**Crossroads Mixed Use
Traffic Study**

PCD File No. SF-21-029 & PPR-21-41

El Paso County, Colorado

Re: Crossroads Mixed Use Traffic Study Letter (PCD File No. SF-21-029 & PPR-21-41)
SWC of Meadowbrook Parkway and Newt Drive
El Paso County, Colorado

212 N. WAHSATCH AVE, STE 305  
COLORADO SPRINGS, CO 80903  
PHONE: 719.555.5485

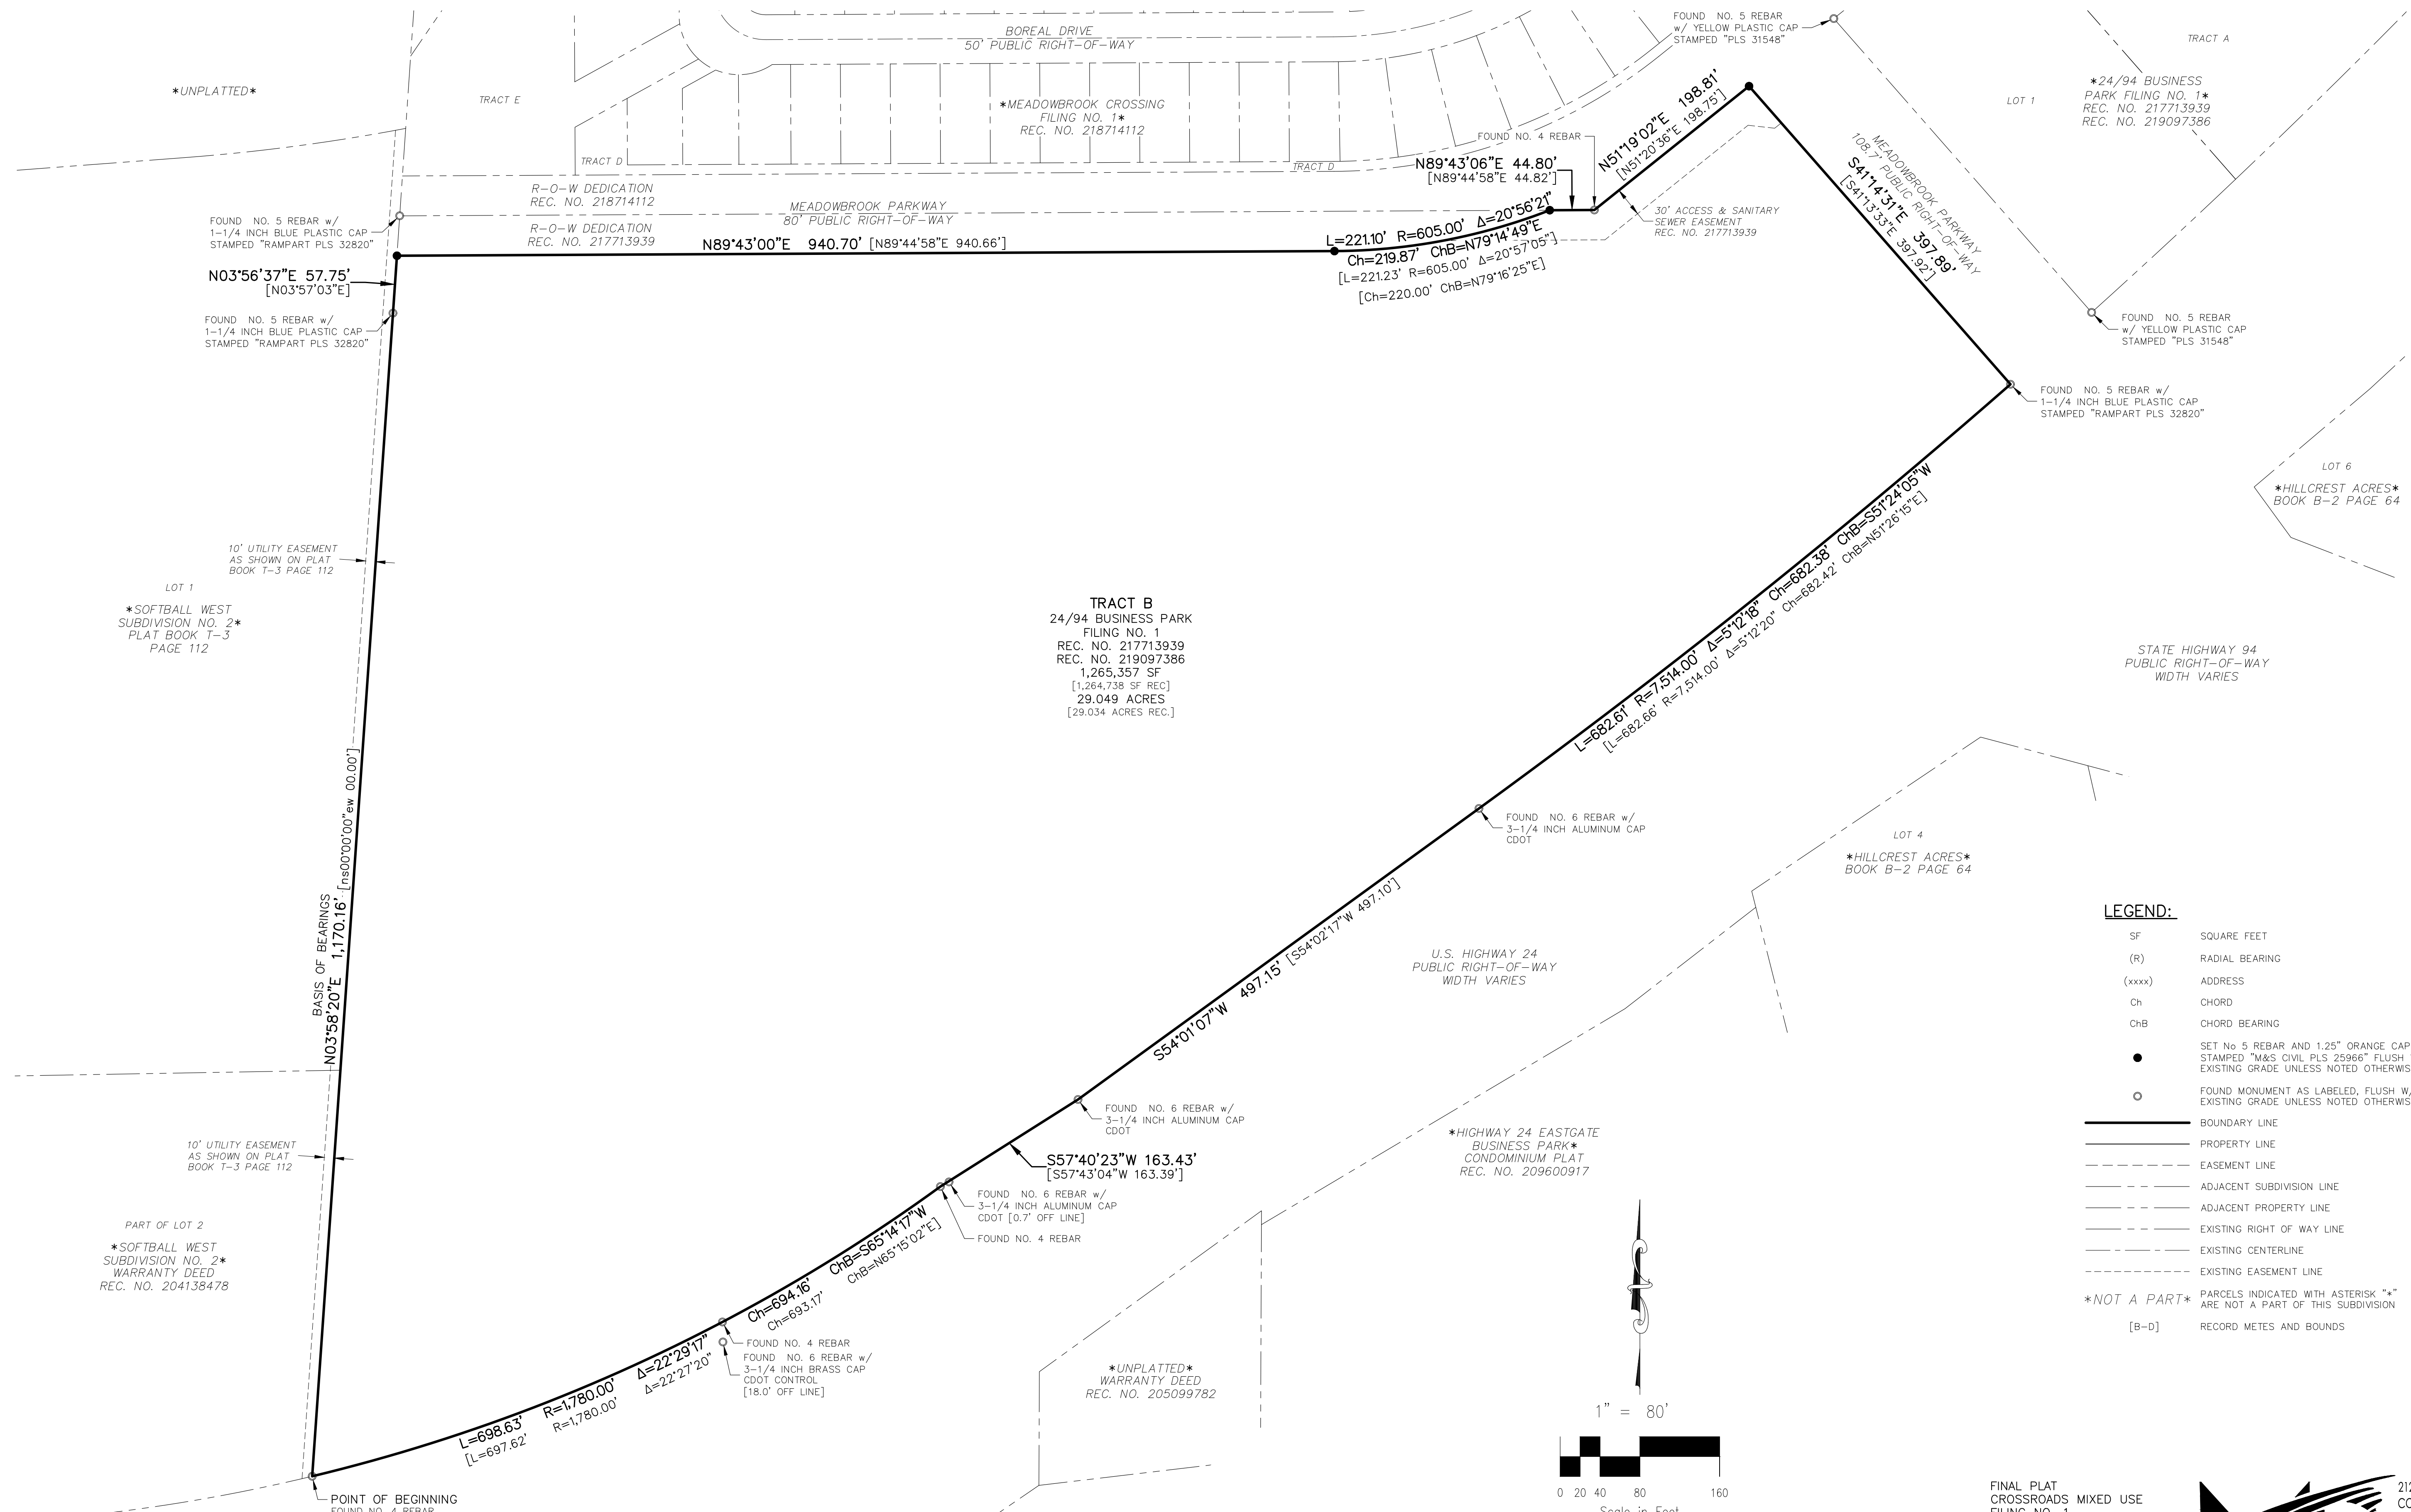
Update . The current application is the final plat process, determination is required at this time. Plat note 19 would need to be updated if the developer is requesting inclusion into a PID.
